From: [Paul Wearne](#)
To: [Michelle Niles](#)
Subject: RE: DA 95/133 MOD 8 Shell Cove Boat Harbour and Marina - EPA comments
Date: Thursday, 4 July 2019 5:13:09 PM
Attachments: [image007.png](#)
[image008.png](#)
[image009.png](#)
[image010.png](#)
[image012.png](#)
[image013.png](#)
[image014.png](#)

The Noise Assessment includes a number of proposed mitigation measures including a 1.8 metre high acoustic wall constructed on the boat ramp carpark boundary at least between proposed residences and carpark, using Colorbond, minimum 20mm timber, masonry or light weight concrete, as shown in Figure 2-2 of the Noise Assessment. The Assessment recommends the wall to be constructed along the boundary indicated in the Figure before development of the dry boat stacking and boat maintenance facilities, and it can be modified later as required. While the supporting development Codes state that a suitably placed and aesthetically treated (compatible with finishes of residential structures and can incorporate suitable artistic/cultural themes) acoustic wall is to be constructed by Frasers on the boundaries of relevant lots.

Figure 2-2 Boat Ramp Carpark

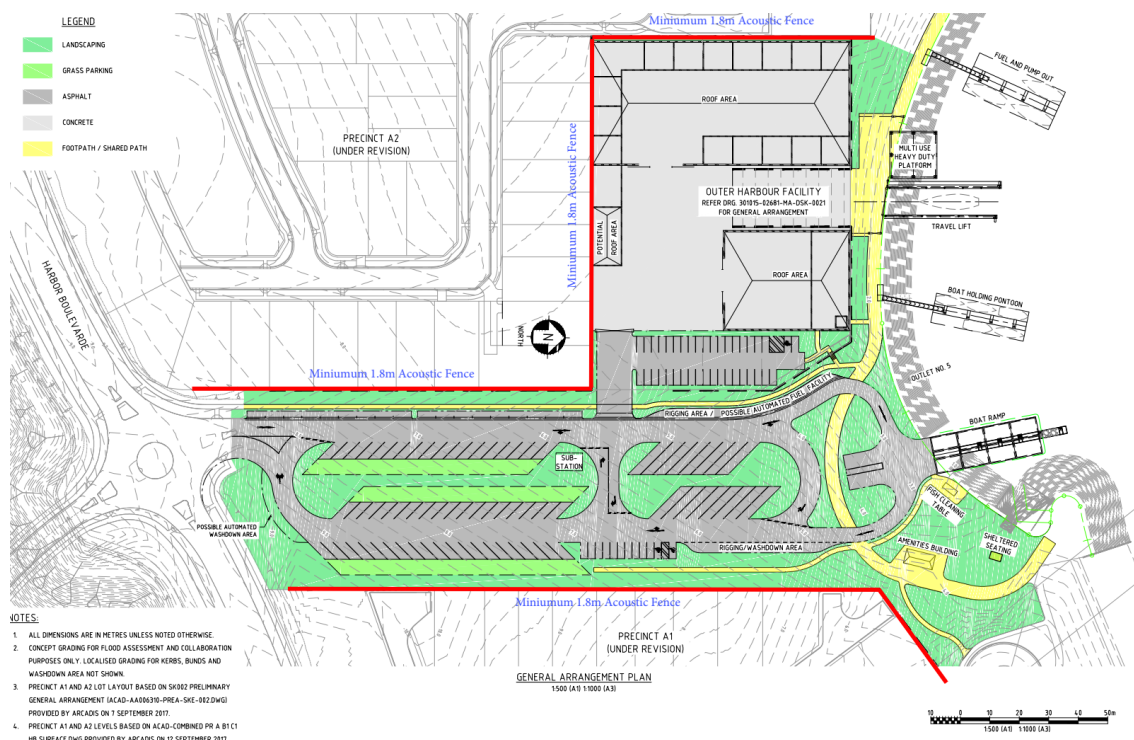
It is important that the required mitigation measures as recommended in the above Noise Assessment are delivered before the operation of the Boat Ramp Carpark, Dry Boat Stacking and Boat Maintenance area and appropriate certification obtained. In addition if the Development Codes are permitting a change to the structural composition of the recommended acoustic wall, any such certification should be undertaken by an appropriately qualified acoustical consultant to ensure any proposed wall can deliver the required attenuation in the Noise Assessment.
